**CITY OF PORTLAND, MAINE
PLANNING BOARD**

May 20th, 2013

Project Name: **Commercial Development including gas station and convenience store with ATM**
Project ID: 2013-086 CBL: 237-A-012
Address: 2282 Congress Street, Portland
Joint Applicants: C J Developers, Inc. and Portland Property Holdings, LLC
Planner: Jean Fraser

F CROSSWALK STRIPING DETAIL
N.T.S.

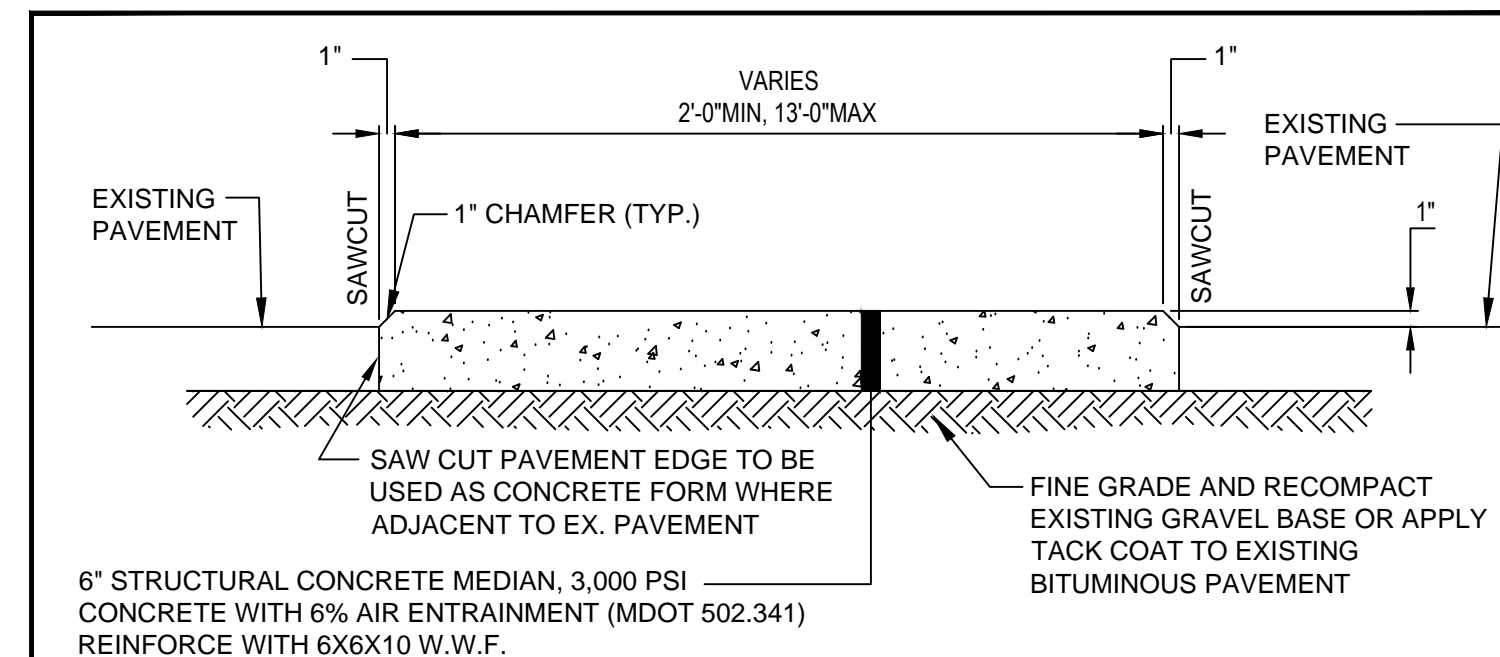
- A pedestrian crosswalk is being proposed on Congress Street between the project site and Blueberry Road. Though the contract rezone process the crosswalk was to include a refuge median island in addition to a flashing sign warning system. Given vehicle turning needs, a refuge island is not feasible at this location. In lieu of the refuge island the applicant shall construct an ADA accessible landing on the northwest radius of Blueberry Road. In addition, the crosswalk pavement marking shall consist of durable paint. Final design elements shall be reviewed and approved by the City.

SHEET TITLE  
**GENERAL IMPROVEMENTS  
PLAN AND PROFILE**

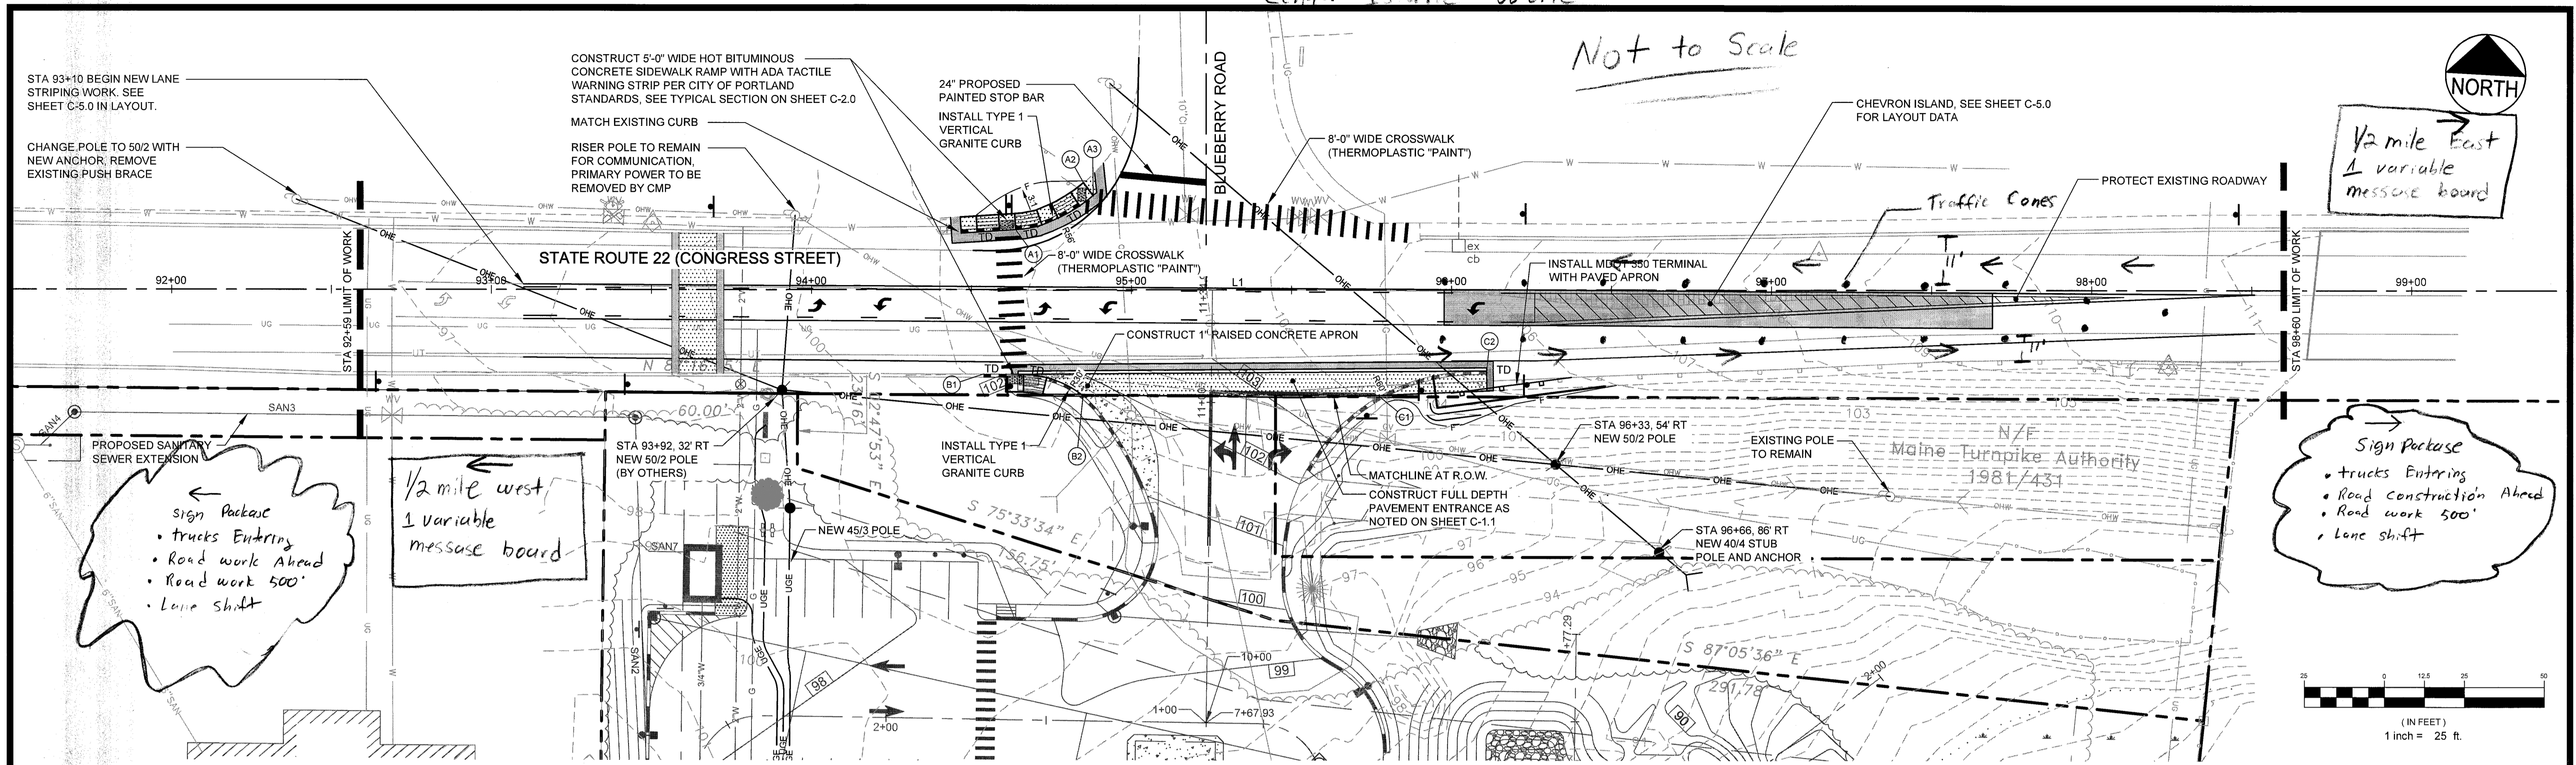
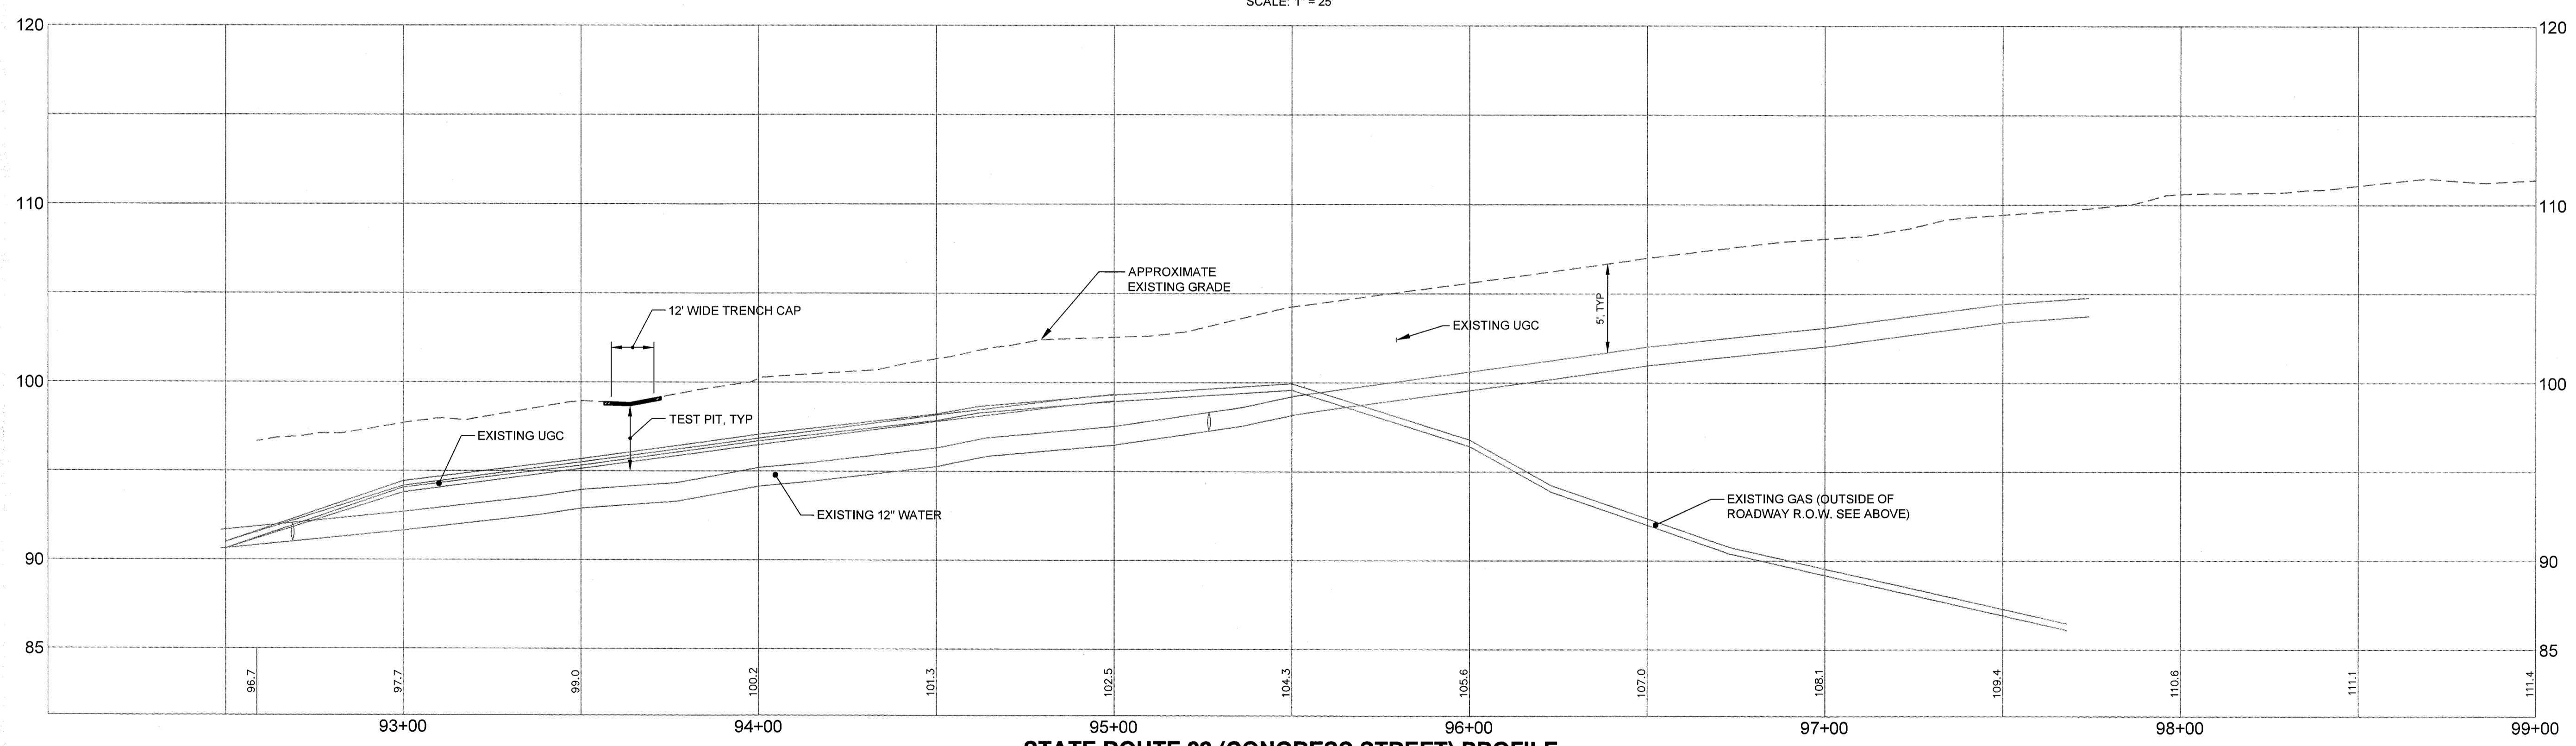
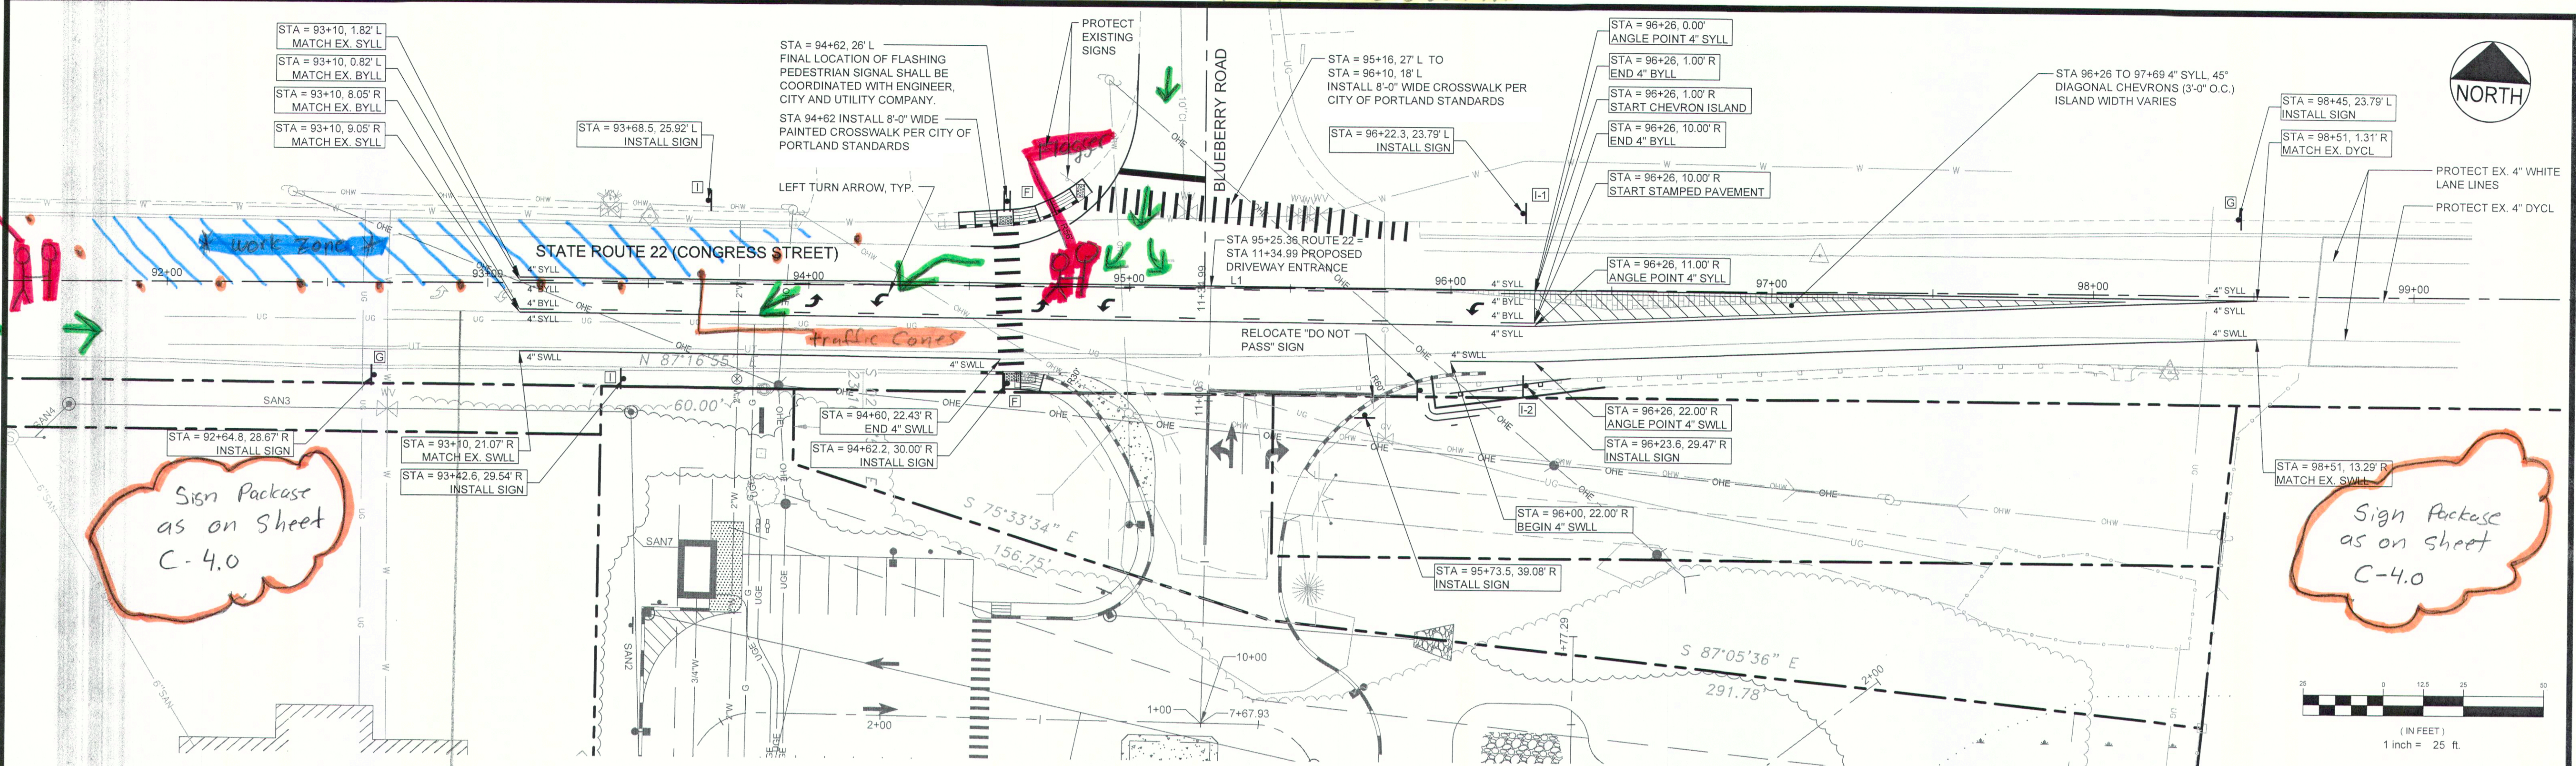
- iv. That the applicant shall submit a revised off-site improvements plan that addresses Tom Errico's memorandum dated 05.09.2013 regarding the left turn accommodations, crosswalk design with ADA landing, and painted crosswalk on Blueberry, for review and approval by the Planning Authority prior to the issuance of a building permit; and

- The applicant has developed an improvement plan for Congress Street such that left-turn accommodations are provided. I support the general concept of the plan provided in the application. Final design plans shall be submitted to the City for review and approval (it should be noted that adjustments to the design may be required during this review process).
